## KITTTITAS COUNTY COMMUNITY DEVELOPMENT SERVICES

November 5, 2009

### RE: Badger Bluff Short Plat (SP-09-00010)

The Kittitas County Community Development Services Department has determined that the Badger Bluff Short Plat (SP-09-00010) is a complete application and hereby grants *conditional preliminary approval* subject to the following conditions:

BADGER BLUFF SHORT PLAT
 A PORTION OF THE NW 1/4 OF SEC. 8, T.17N, R.20E., W.M.
 KITTITAS COUNTY, WASHINGTON

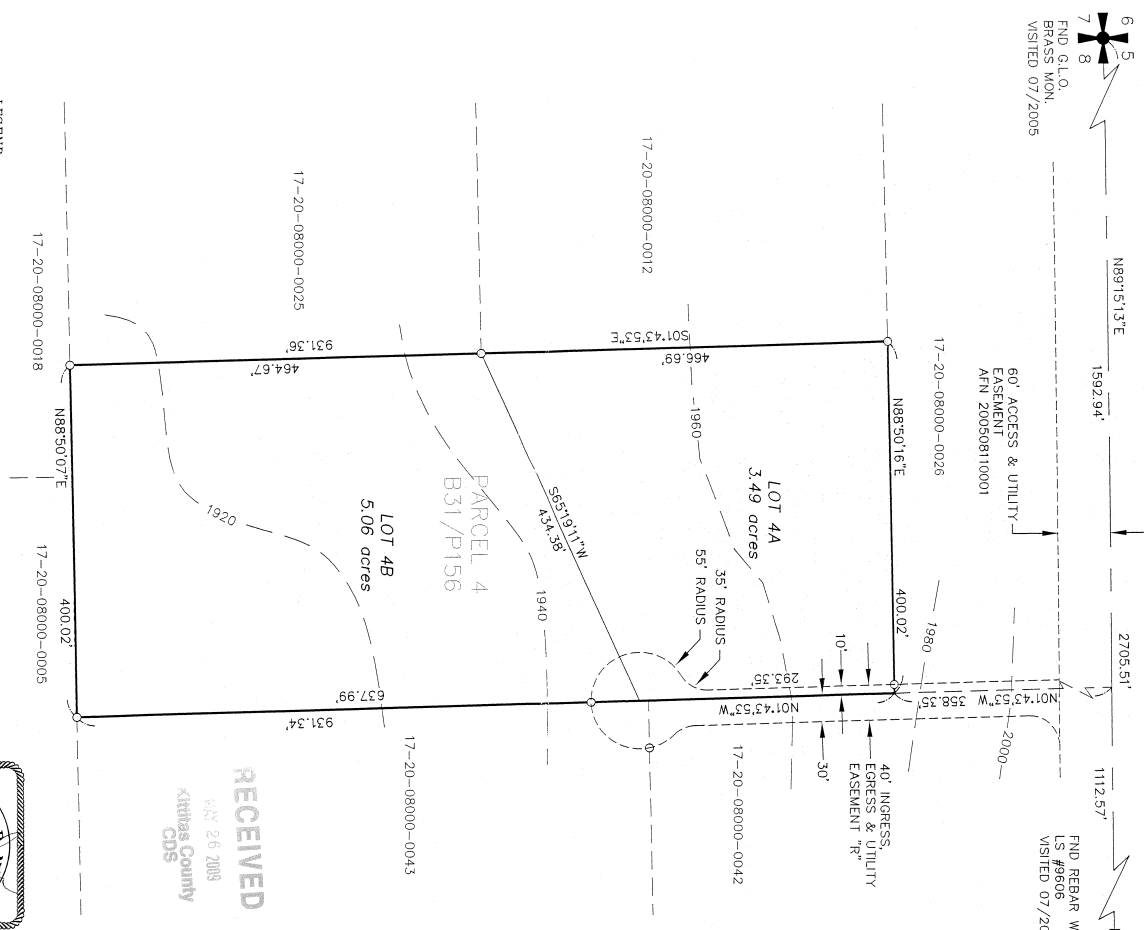
1. Both sheets of the final mylars shall reflect short plat number SP-09-00010 and an accurate legal description shall be shown on the face of the final plat.

11. The addresses shall be clearly visible from both directions at the County Road for all properties.
12. The Fire Department access road shall be capable of supporting 75,000 lbs in all weather, be 20' wide, provide 13'6" vertical clearance and provide for adequate turn-around for fire department apparatus.
